REQUEST

Current Zoning: N1-A (neighborhood 1-A)
Proposed Zoning: N2-A(CD) (neighborhood 2-A, conditional)

Approximately 3.52 acres located along the north side Johnston Oehler Road and south of Barrow Road.

The petition proposes to develop a residential community to allow up to 45 multi-family attached dwelling units.

RZ-1.0

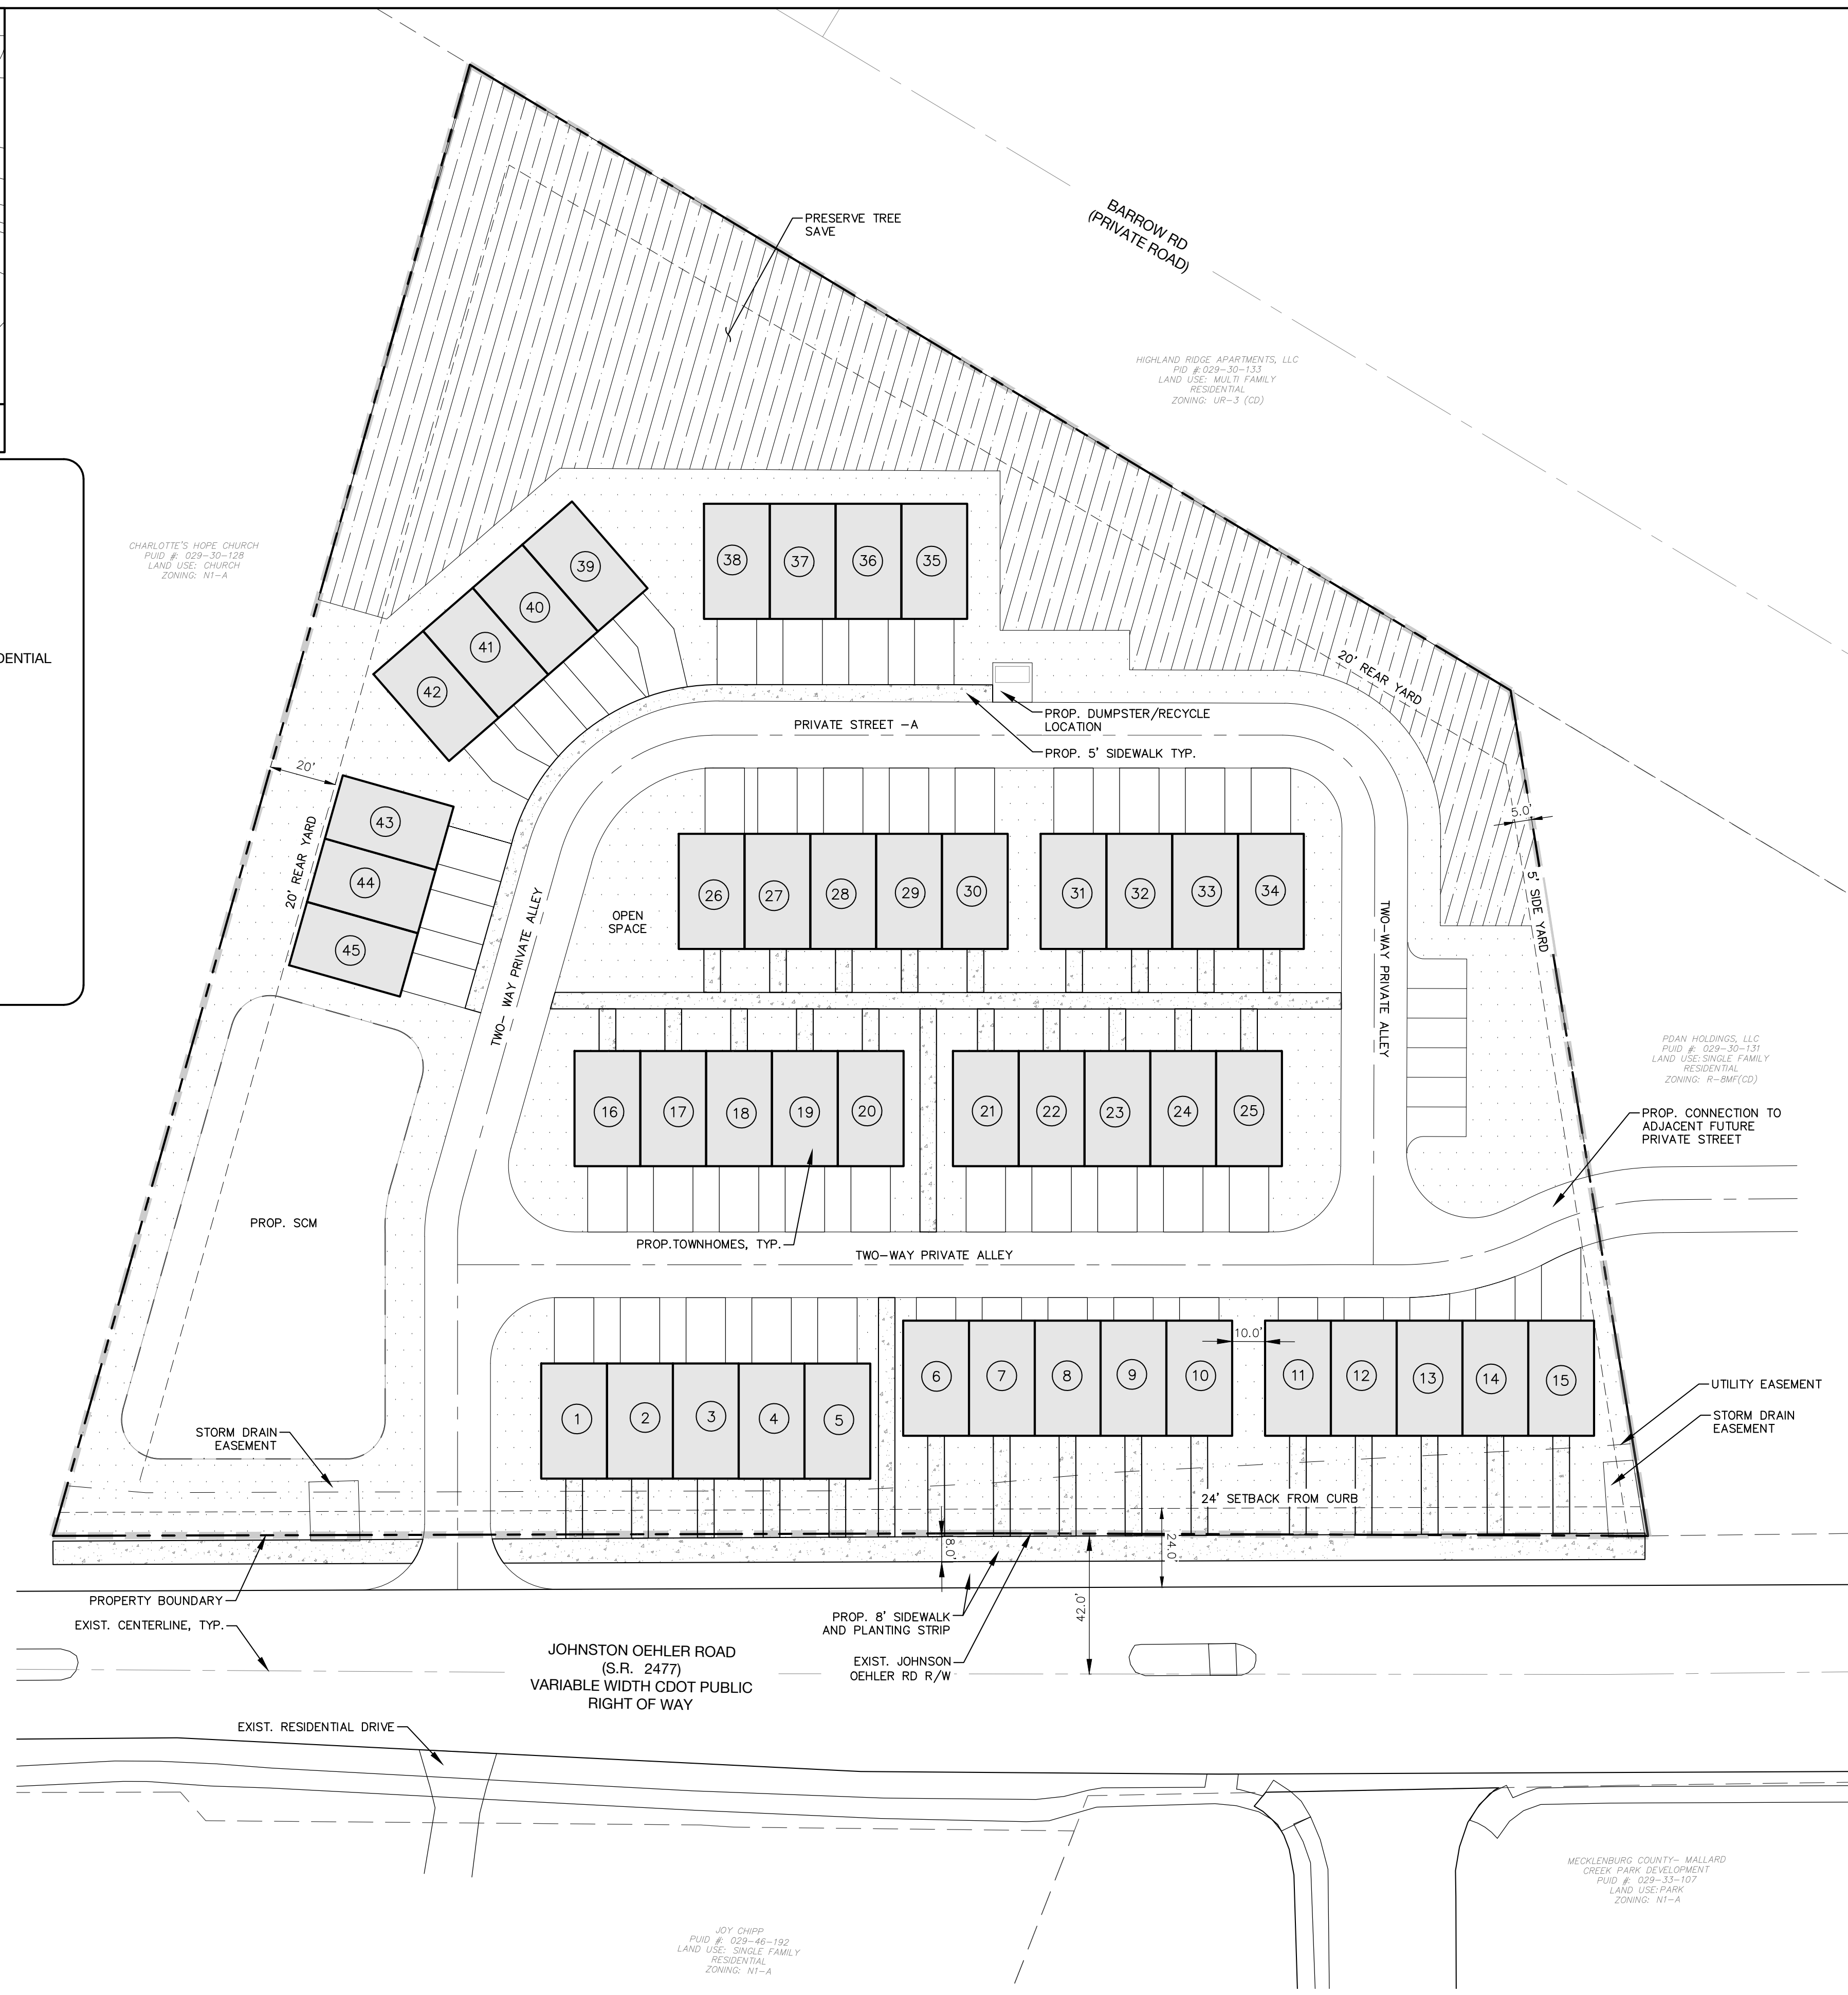
1. Site access is to line up with the residential driveway on the southern side of the roadway.

2. Revise site plan and conditional note(s) to commit to installing a signalized pedestrian crossing at the existing pedestrian crossing location that would allow for connection to Mallard Creek High School.
3. Remove conditional note referencing reverse angle parking.

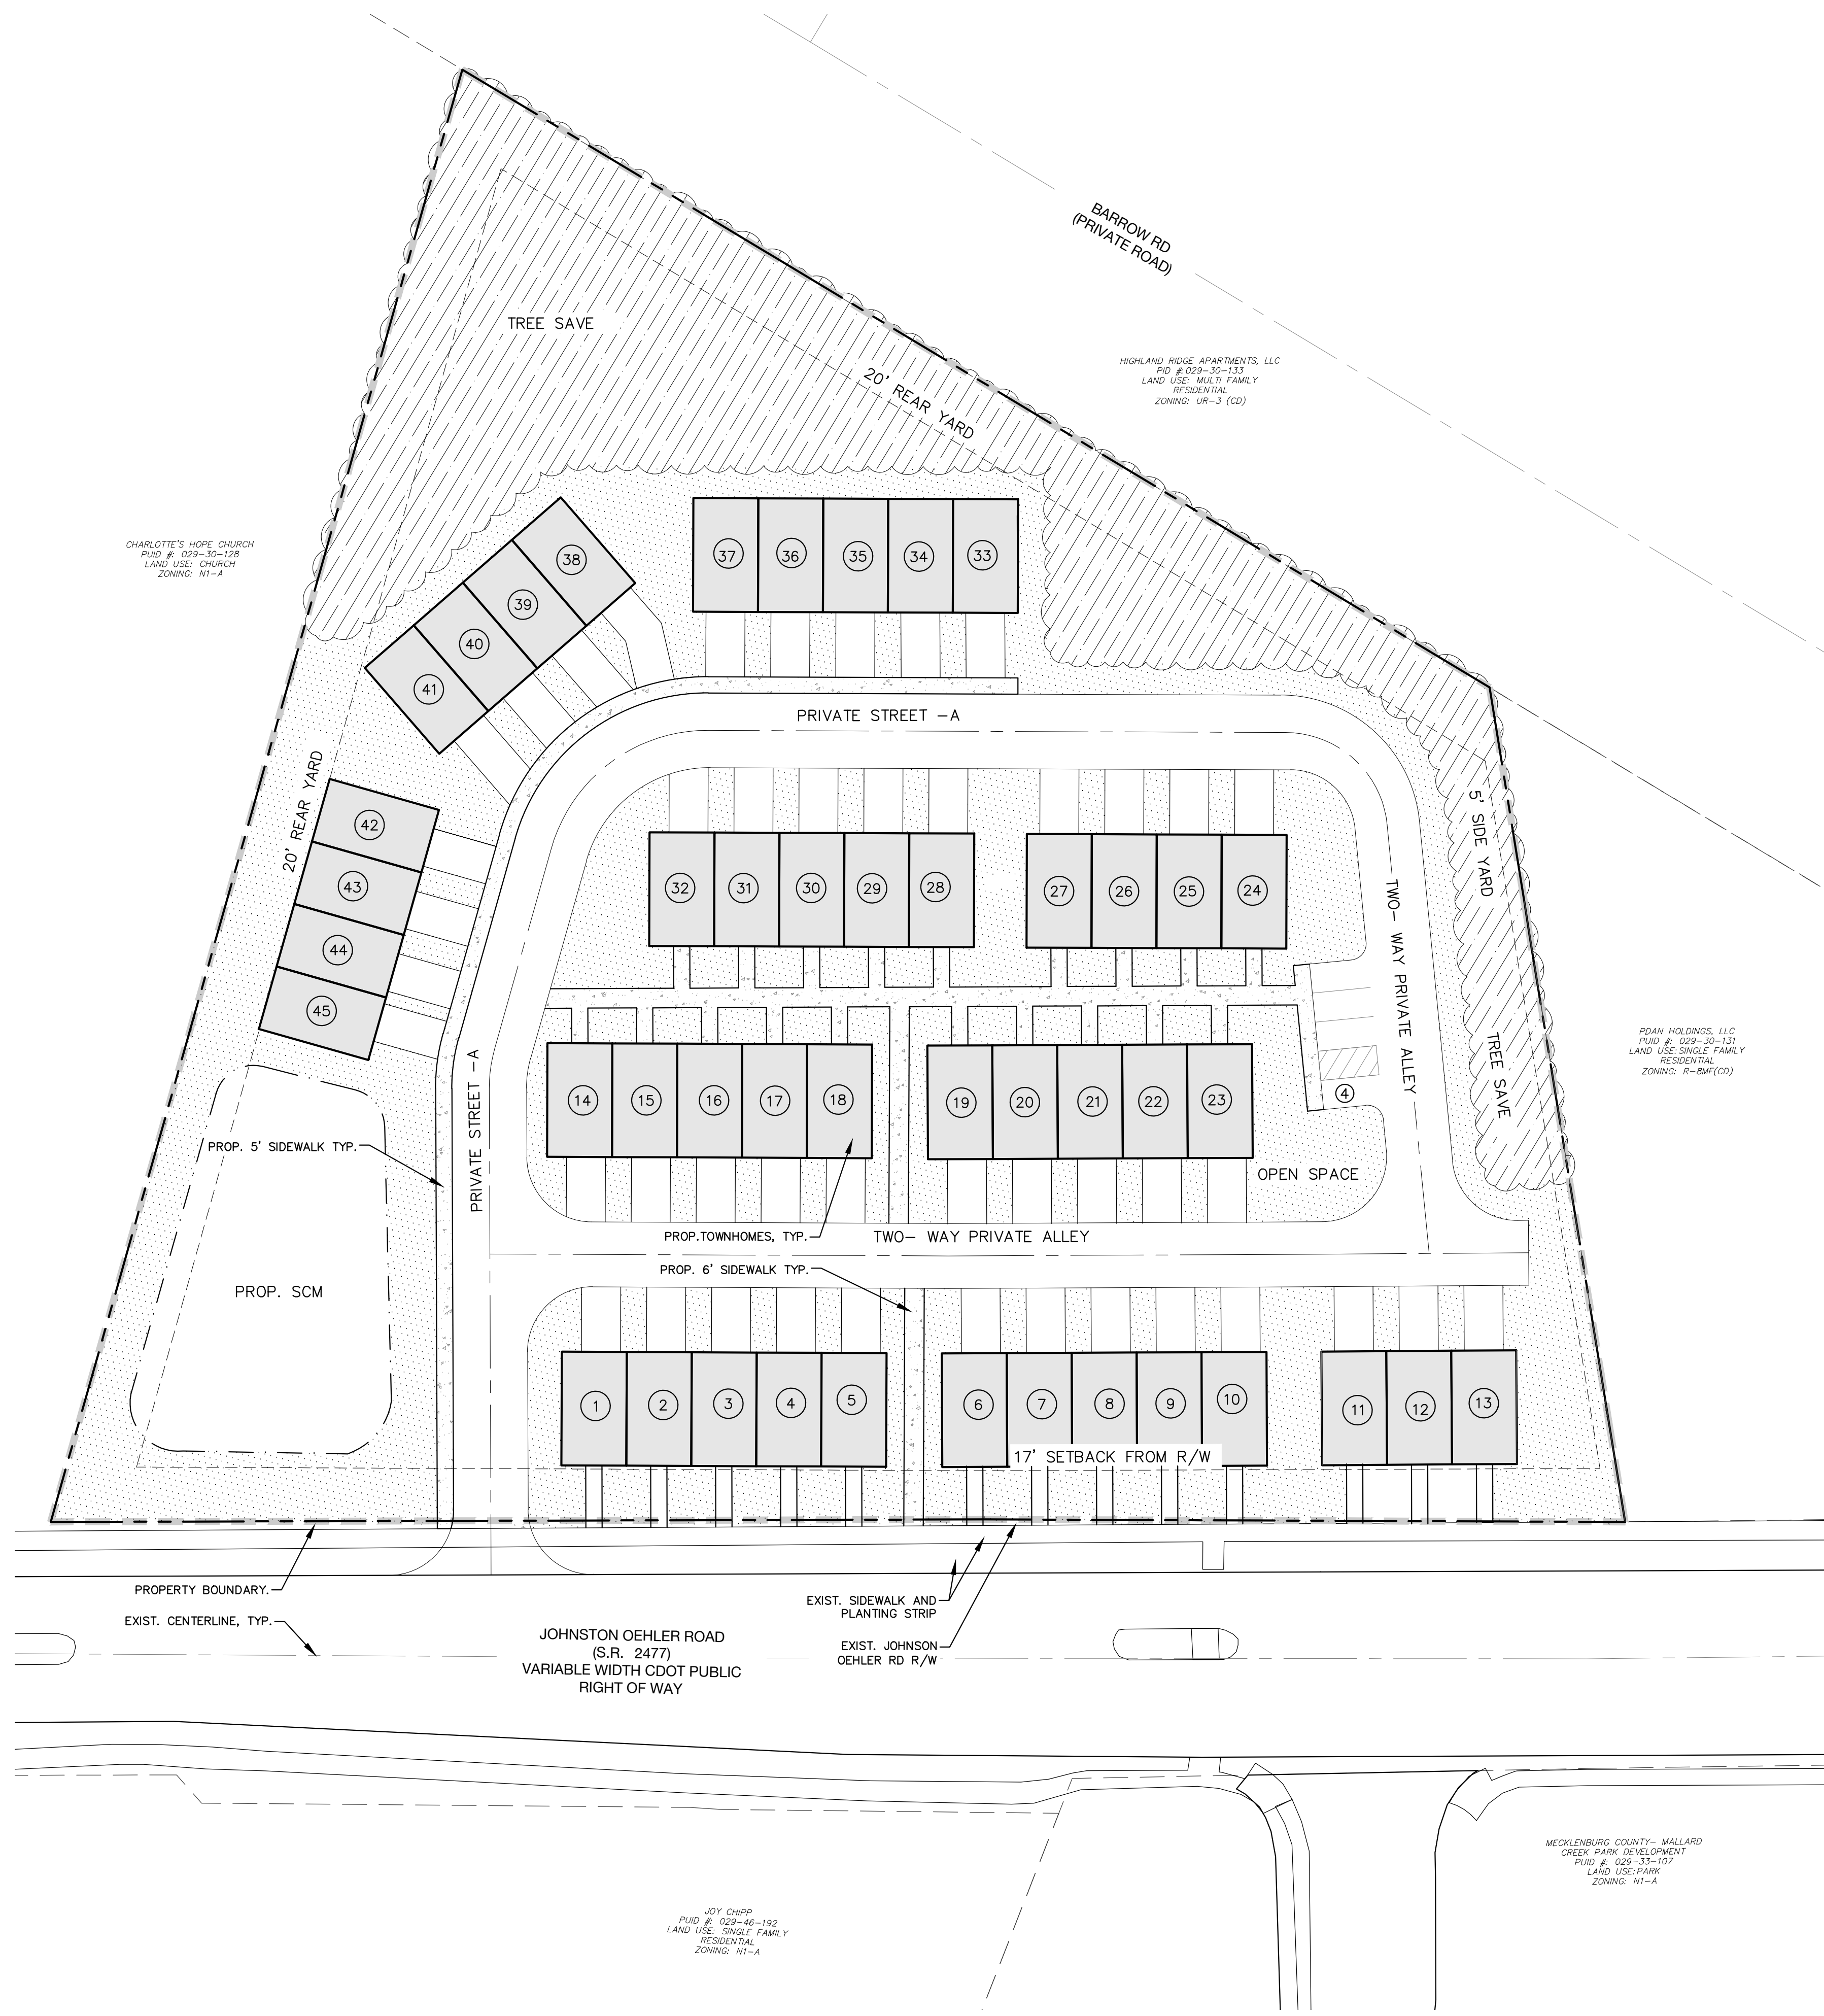
4. Minimum tree save width for protected area is 30-feet.
5. Tree survey required.
